Yorkshire Green Energy Enablement (GREEN) Project

**Document 8.28 Applicant's Comments on Interested Parties' Deadline
5 Submissions**

**Final Issue A
July 2023**

Planning Inspectorate Reference: EN020024

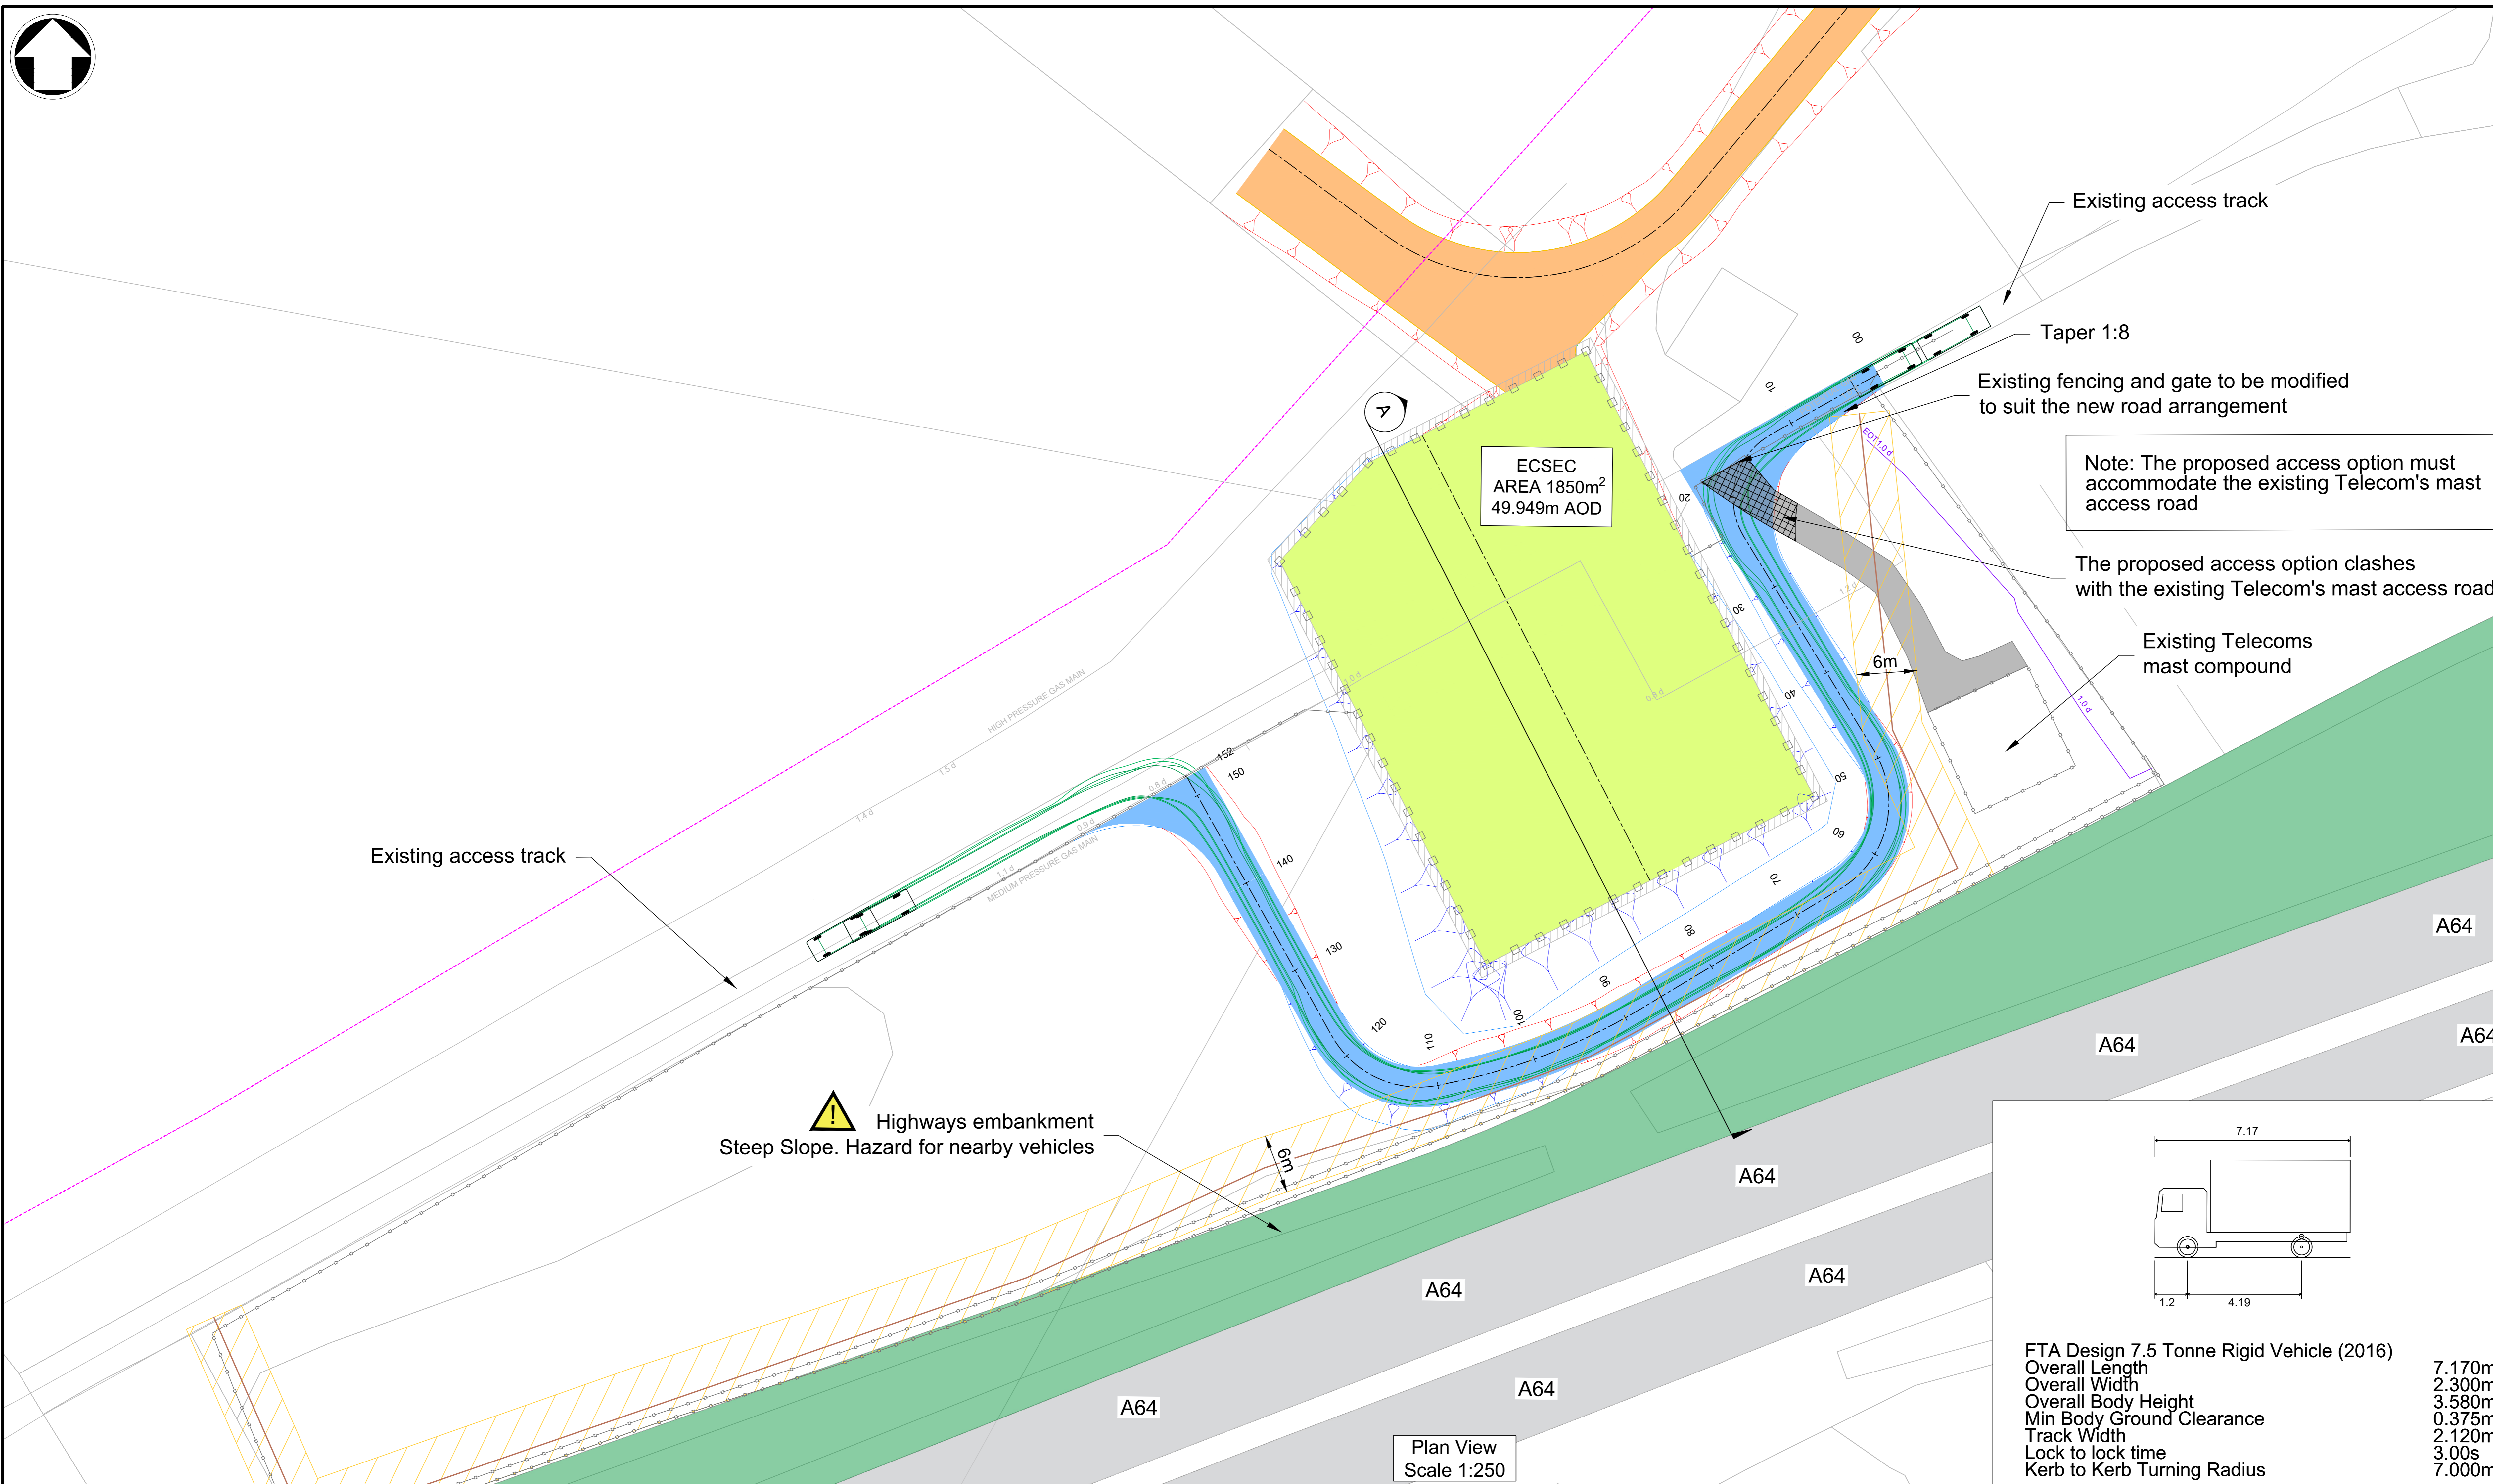
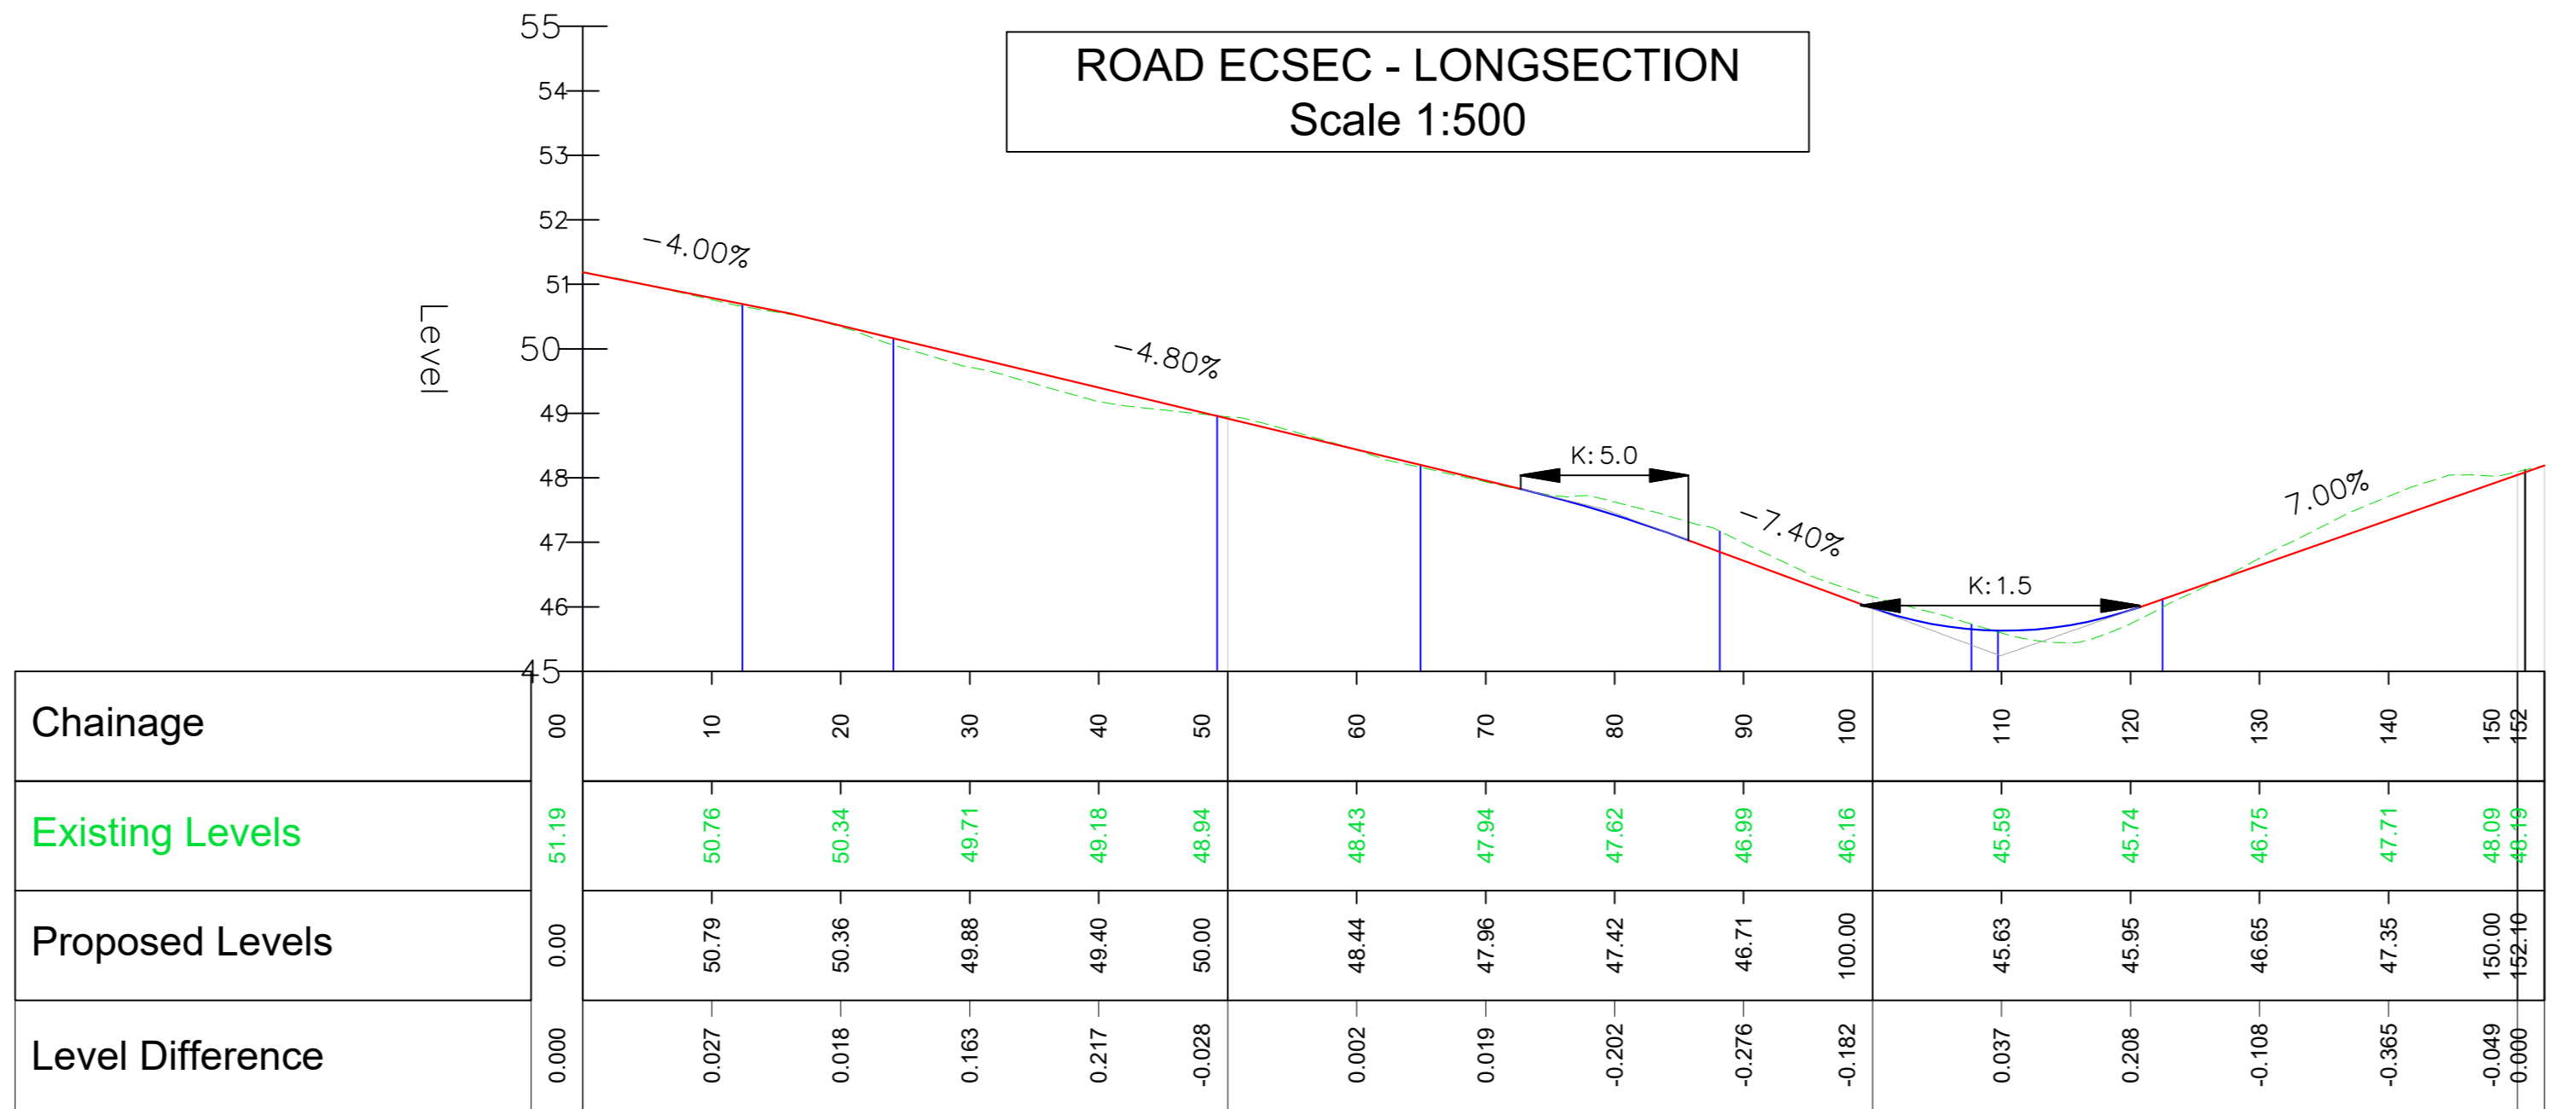
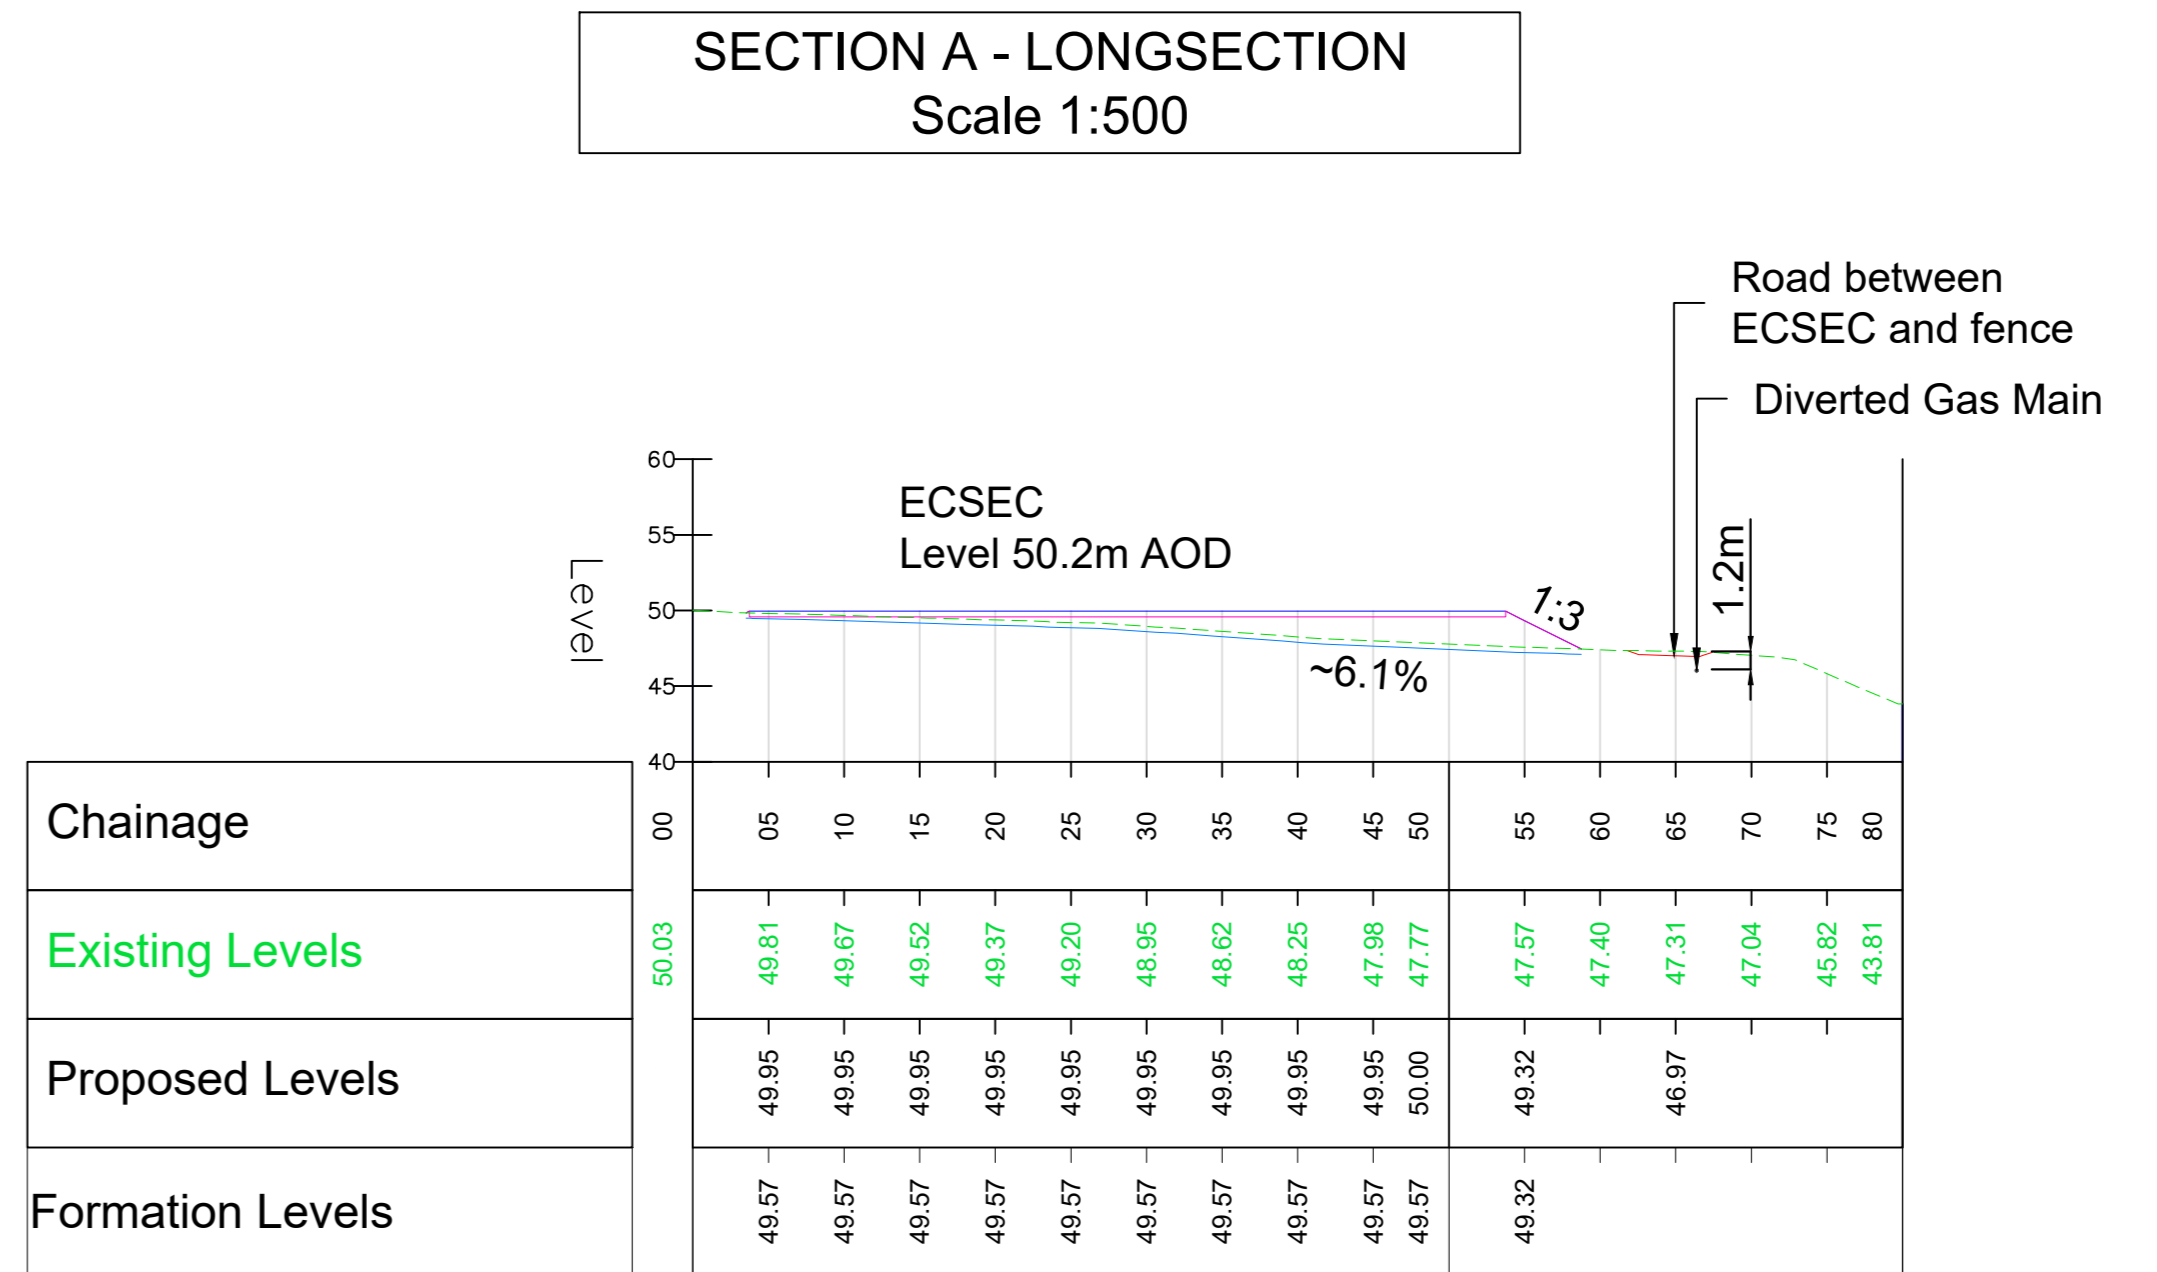
Reference	Topic	Applicant's Response
		<p>retaining wall would not be suitable solution for the use at Tadcaster East CSEC and is not proposed.</p> <p><u>Crop Planting and Access Arrangements</u></p> <p>Access to the landowners field would be maintained with a right granted across the permanent access to the CSEC. Furthermore, National Grid is able to provide a further access gate along the proposed permanent access road to the Tadcaster West CSEC that would enable access to the lower part of the field. This would enable two accesses to the field should two different crops be required to be planted.</p> <p><u>Tadcaster East CSEC – access rights</u></p> <p>The landowner has referenced narrative provided by National Grid in [REP1-015] Table 2.13, Point 13.5 in which National Grid state that <i>should the landowner wish to retain the land despite its restricted accessibility, then National Grid would be willing to agree not to proceed with the acquisition in this part of the Order limits.</i> This statement relates to land to the West of Tadcaster East CSEC and was clear in its intention that this land would have restricted accessibility as National Grid are not proposing any access to this parcel of land. National Grid have included land plot D1-15 as compulsory acquisition as shown on the Land Plan Section D (Document 2.5.4(C)).</p> <p><u>Tadcaster West CSEC Access</u></p> <p>National Grid requires unrestricted access for the operation and maintenance of the cable sealing end compound, and to that extent would need to ensure that fly tipping and unauthorised parking in the bellmouth be prevented at all</p>
